## Department of Primary Industries

### **Prestons Warehouse and Distribution Centre (SSD 7155) Comment on the Environmental Impact Statement**

Mitchell Isaacs  
**Director, Planning Policy & Assessment Advice**  
20/04/2016

Drawing:
SITE STAGING PLAN

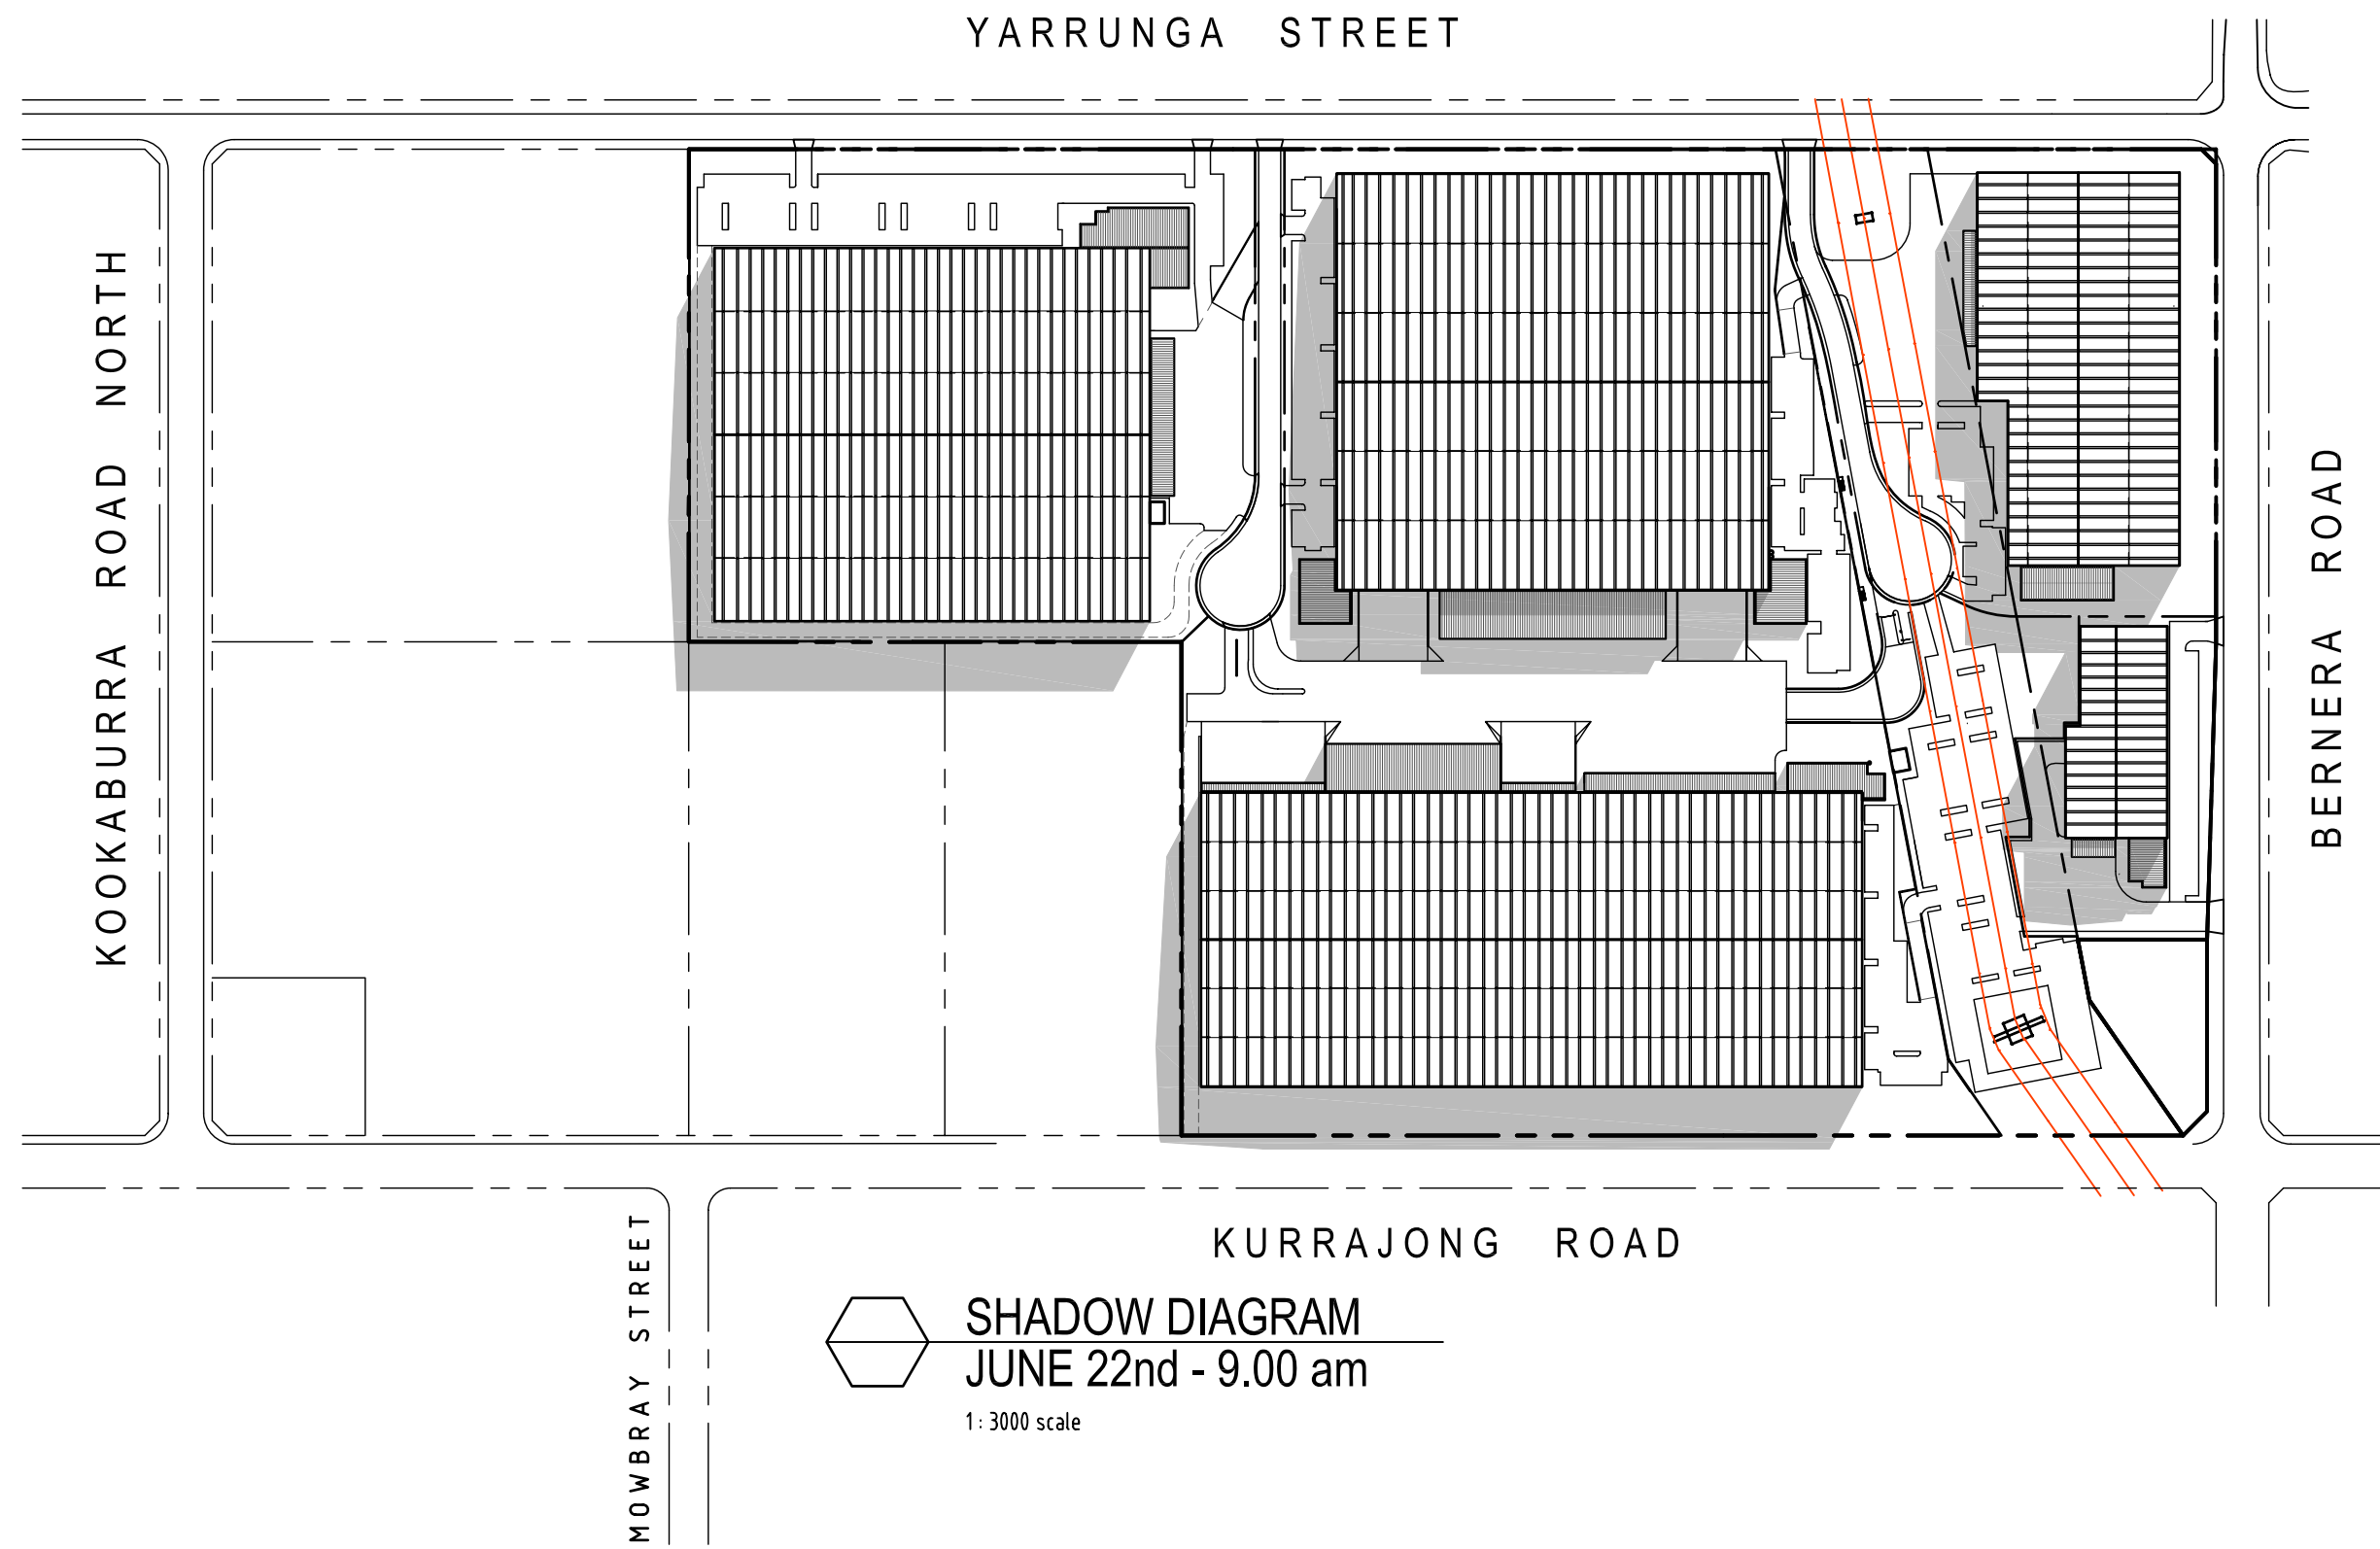
The EIS mentions agricultural activities to the west of the site for the warehouse (*'West - Similar to subject site. Predominantly undeveloped, grass covered sites with evidence of market gardening, p 20.'*) The EIS and a desktop inspection note greenhouse horticulture (see figures at Attachment A). The proponent will need to ascertain whether the adjoining

market garden is still operational, and if so, consider whether any overshadowing of the production area by the warehouse is a concern for the market garden operators.
